September 28, 2023

Re: PA23-005 – Creekside PRD – Technical Review 2
7808 40th Street, 7811 & 7715 40th Street NE, APNs 29050200100200,
29050200100300, and 29050200100400

The following comments are required to be addressed prior to a SEPA determination being issued:

REFERENCE LINE SEE SHEET PP-02

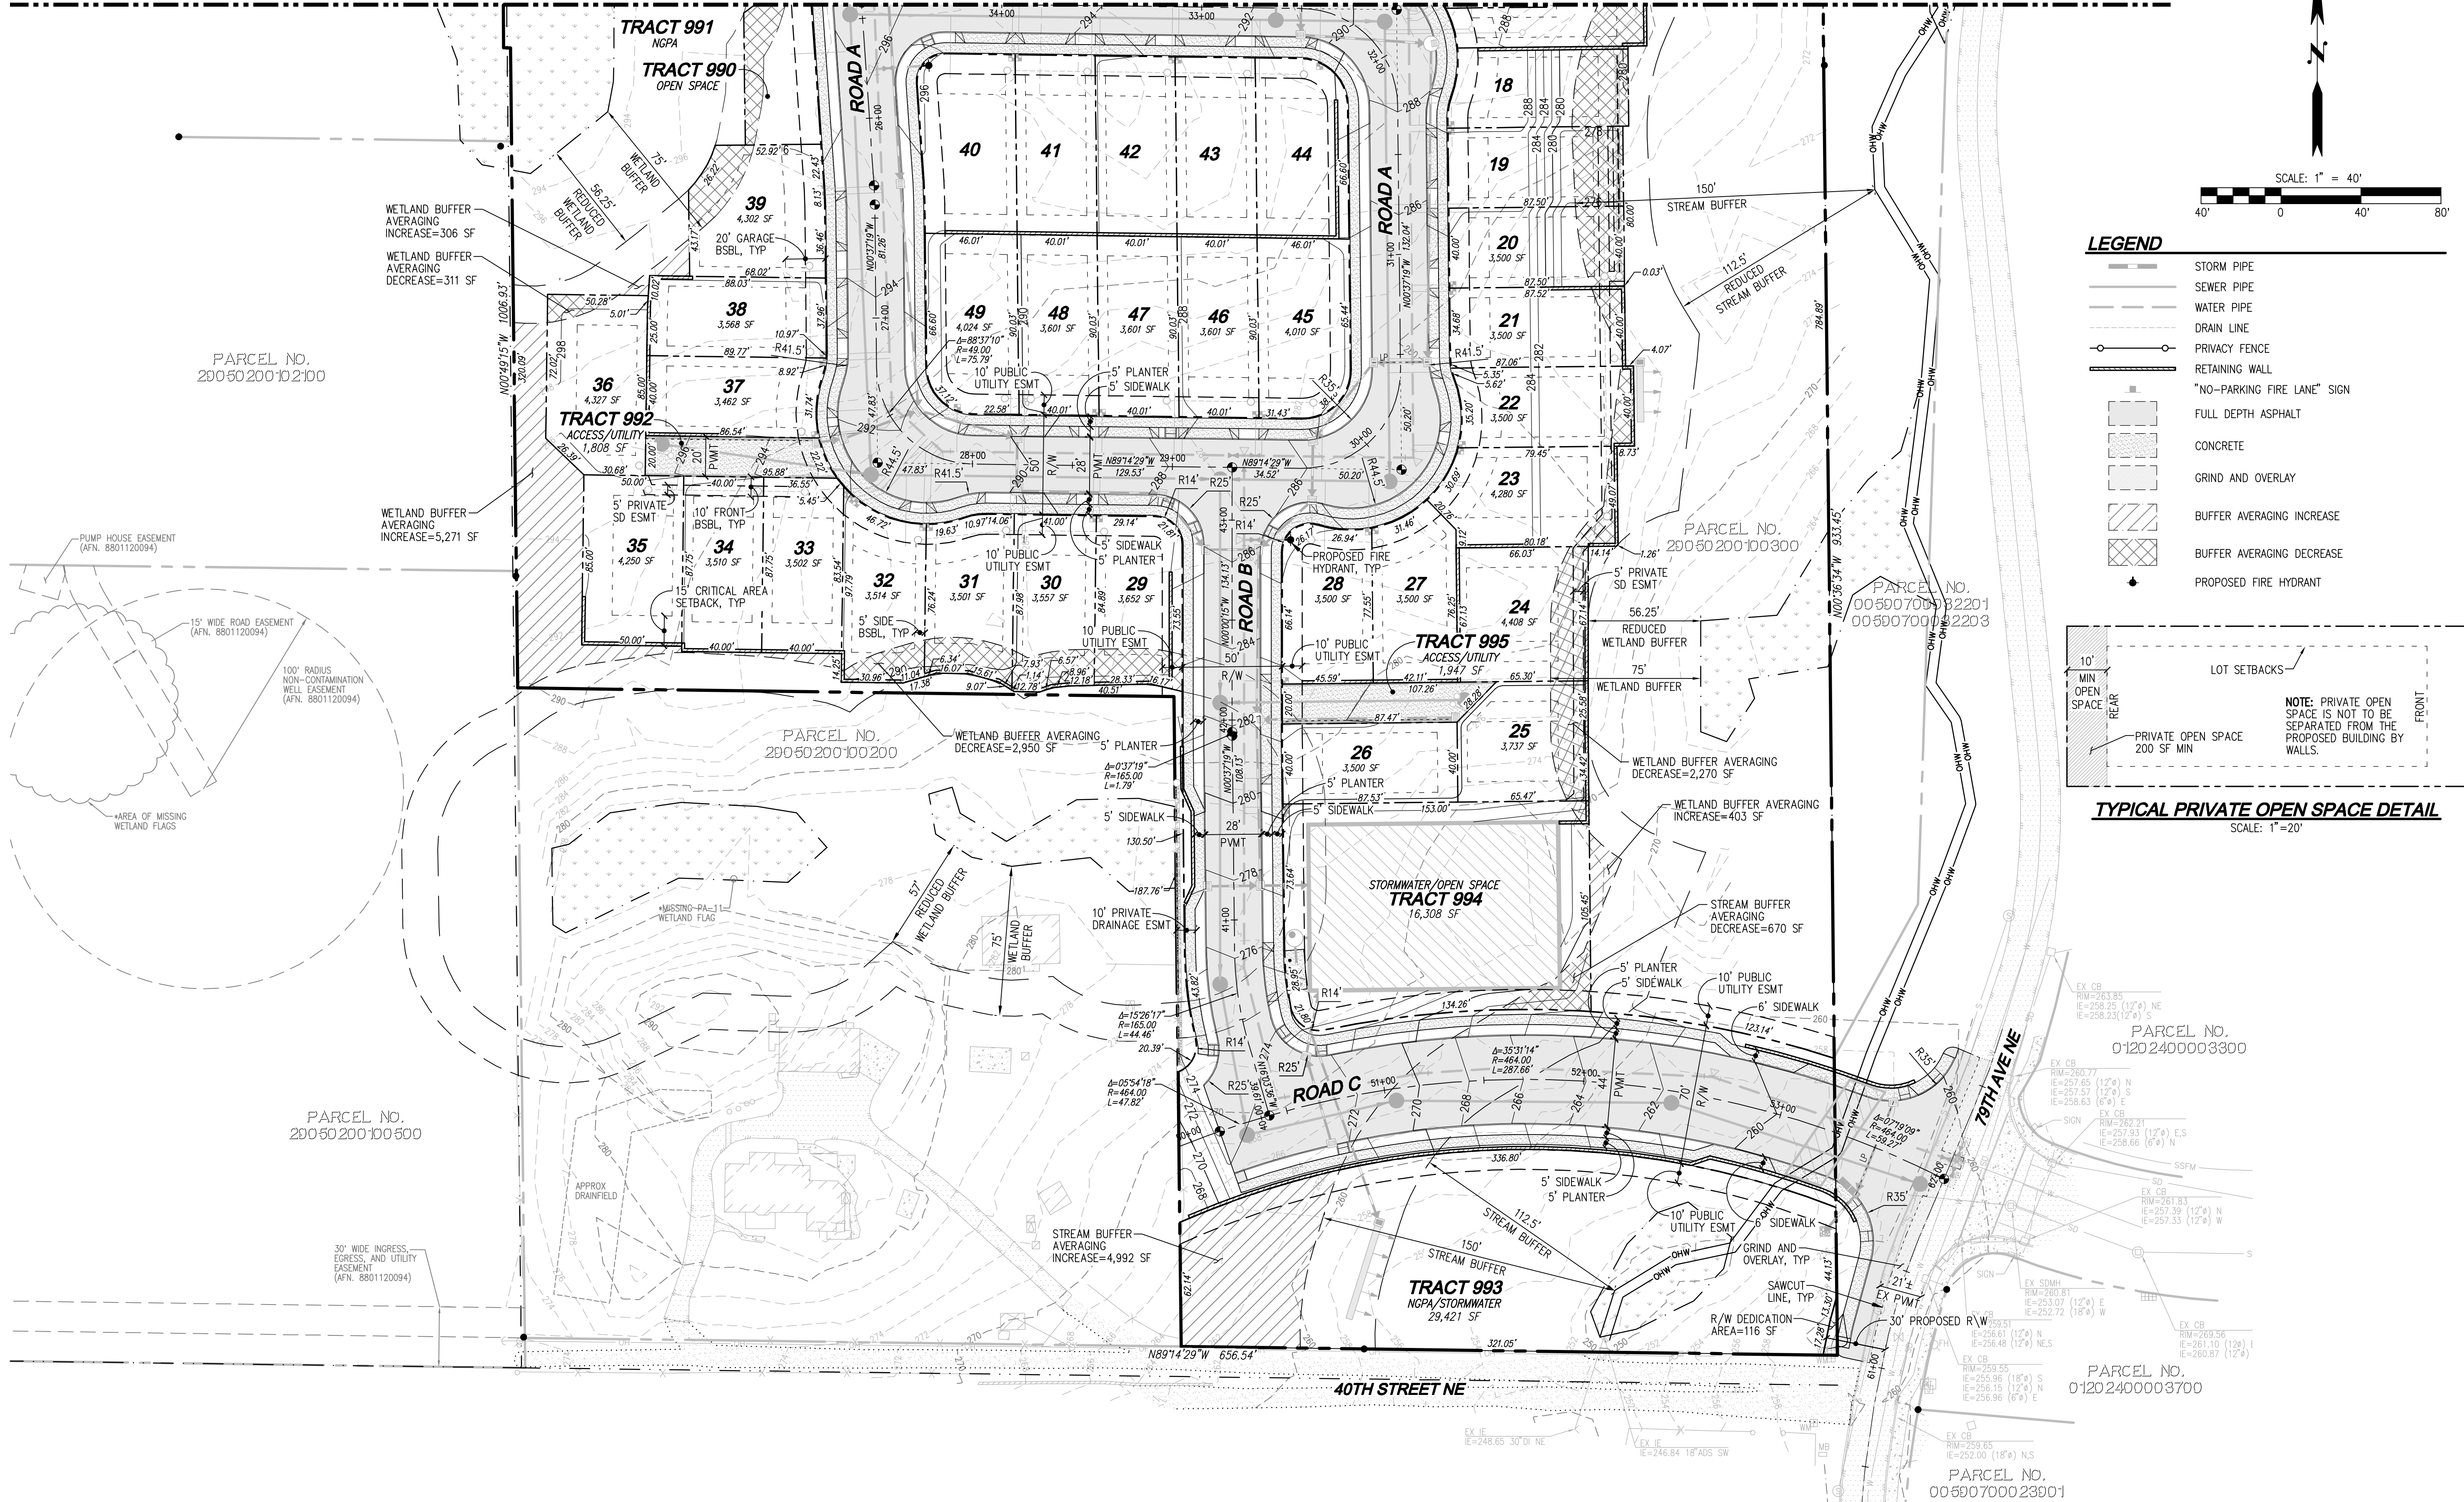
3. The setbacks for lot 25 should be revised as depicted below.
